**Re: SSD-17424905 – 20 Avon Road, Pymble**

*'Redevelopment of Pymble Ladies College-Grey House Precinct, comprising a five-storey building to accommodate the following:*

We act on behalf of the owners of No.59A Pymble Avenue, Pymble to the south-east of the proposed development.

ISSUE
AR-DA-C10-AA-01
8

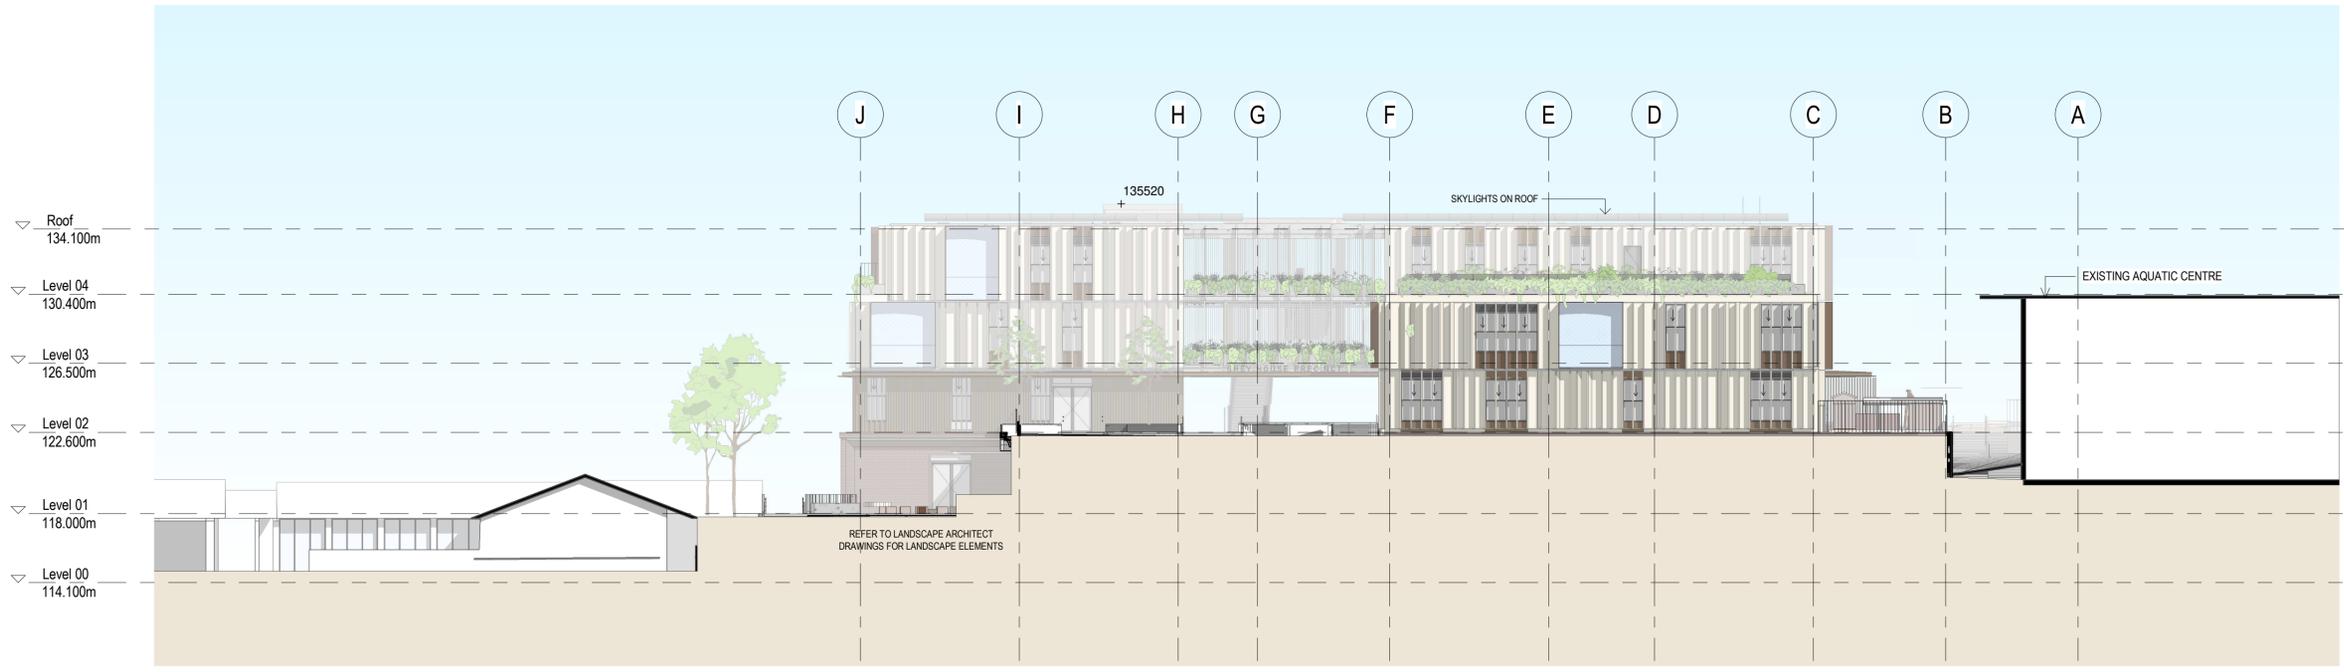
The proposed five storey (5) Grey House building is of a bulk, scale and design that is unsympathetic to the low-density residential environment to the south east. The proposed building should be amended to be of a lesser height, more recessive in design, bulk and scale and provide a transition in scale to the two (2) storey dwellings directly to the south.

Figure 2: Extract of architectural drawings showing southern elevation (Dwg. No. DA-C10-AA-01) of the proposed development (Source: BVN Architecture)

Whilst we note that no maximum building height applies to the site, the proposed 20m+ building dwarfs the surrounding single and two (2) storey residential dwellings directly to the southeast, significantly impacting on the visual privacy and visual amenity of No. 59 Pymble Avenue due to the five (5) storey scale and 62m length of the proposed southern elevation.

AR-DA-C10-AA-02 | 9

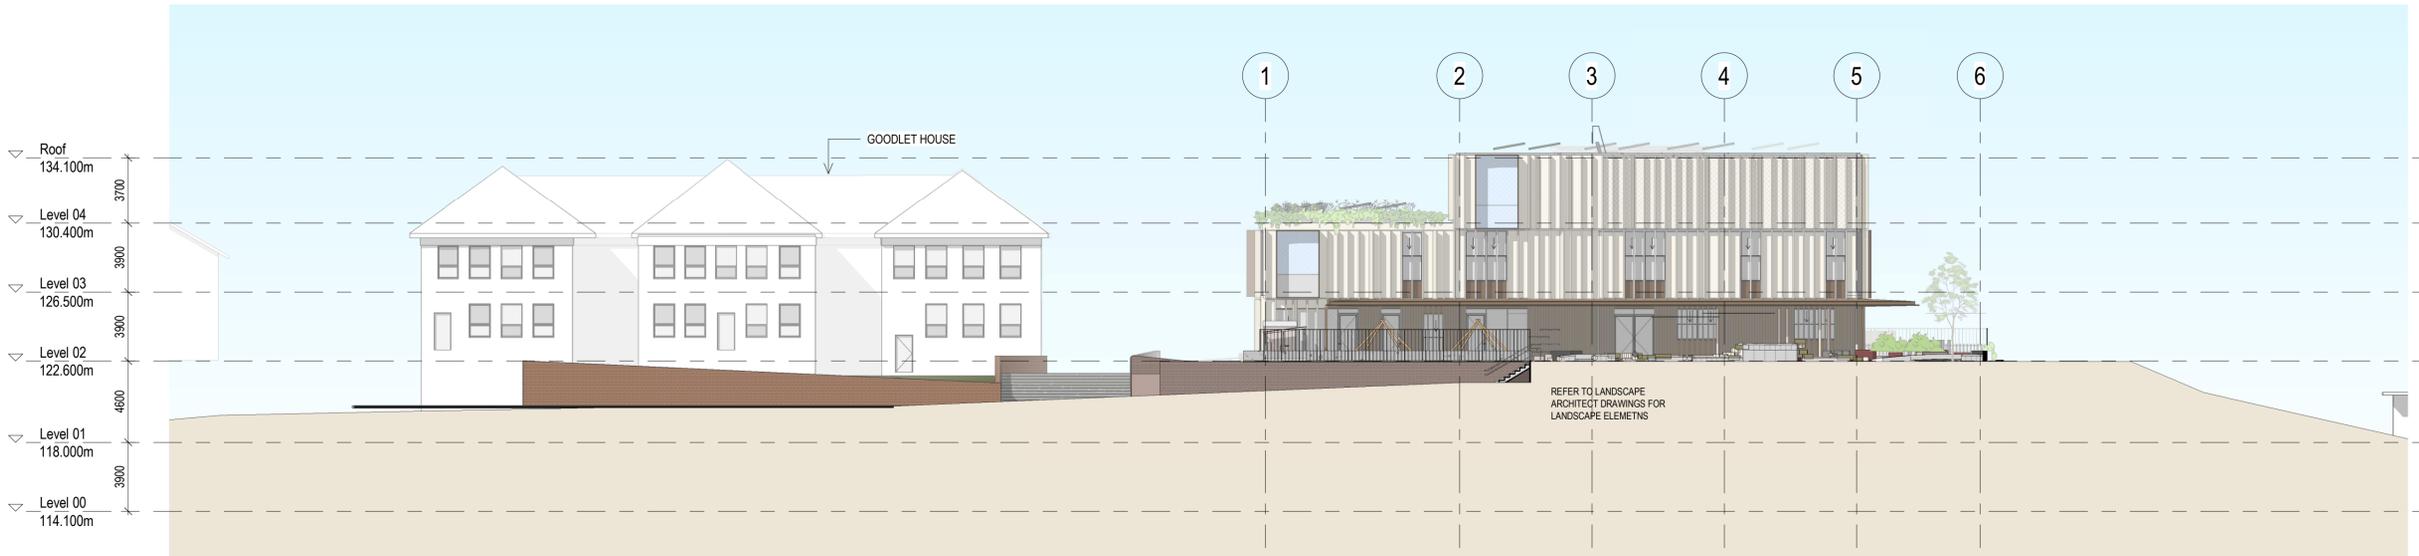
Figure 1: Extract of architectural drawings showing eastern elevation (Dwg No. DA-C10-AA-02) of the proposed development (Source: BVN Architecture)
